CITY OF PORTLAND

BUILDING PERMIT

Job ID: 2012-04-3774-ALTCOMM

has permission to convert existing garage into residential office space (Adult Care Facility).
provided that the person or persons, firm or corporation accepting this permit shall comply with all of the provisions of the Statutes of Maine and of the Ordinances of the City of Portland regulating the construction, maintenance and use of the buildings and structures, and of the application on file in the department.

STAIR PLATFORM detail

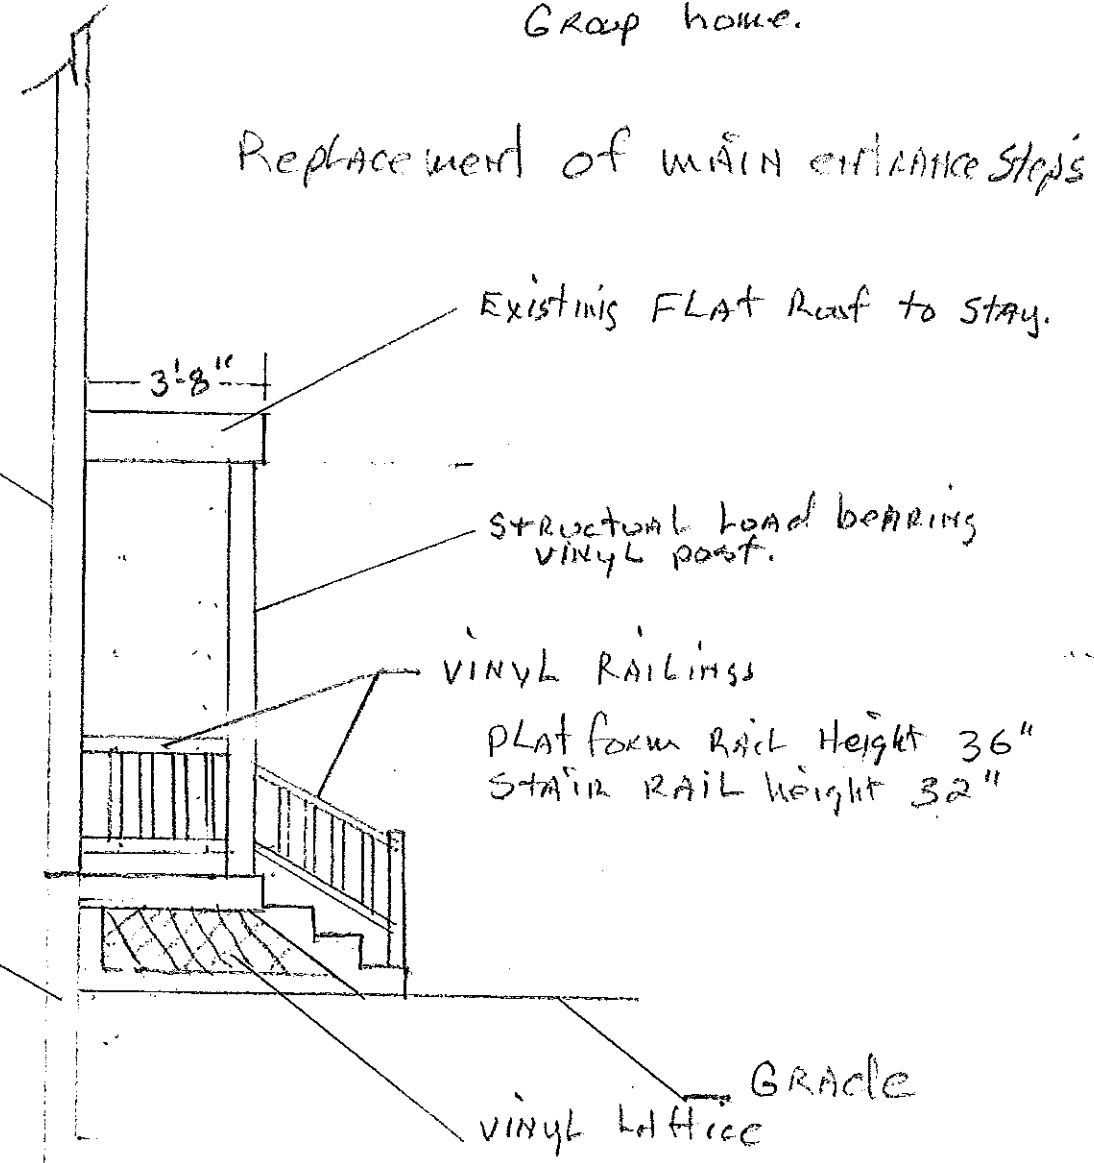
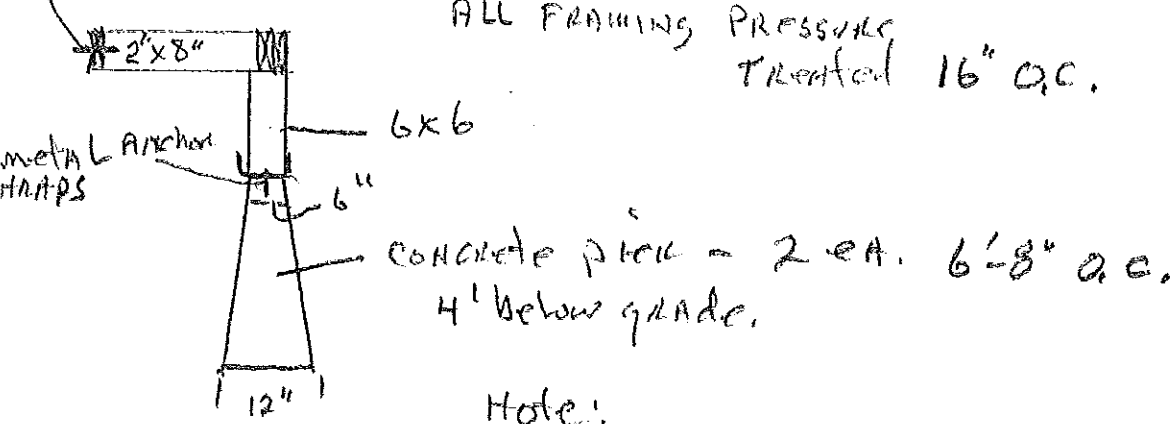
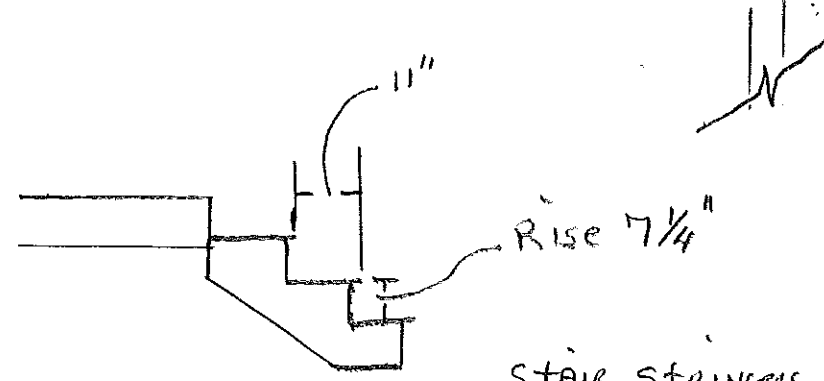
1. This permit is being approved on the basis of plans submitted. Any deviations shall require a separate approval before starting that work. The offices are for the staff serving the handicapped persons.
2. This property shall remain a handicapped family unit. Any change of use shall require a separate permit application for review and approval.
3. This permit is being issued with the condition that the front porch is being replaced within the existing footprint.

1. Separate permits are required for any electrical: plumbing, sprinkler, fire alarm, HVAC systems, commercial hood exhaust systems and fuel tanks. Separate plans may need to be submitted for approval as a part of this process.
2. See attached documentation (Section R311.3) Floors and **landings** at exterior doors requirements: opening limitations, stair width, and **railing height**.
3. **Porch Beams/** New door Header(s) sizing and spans shall comply with Table R502.3.1(2), see attachment.
4. Ventilation of this space is required per ASRAE 62.2 , 2007 edition. Insulation shall comply with the IECC, 2009 (Maine State Energy Codes).
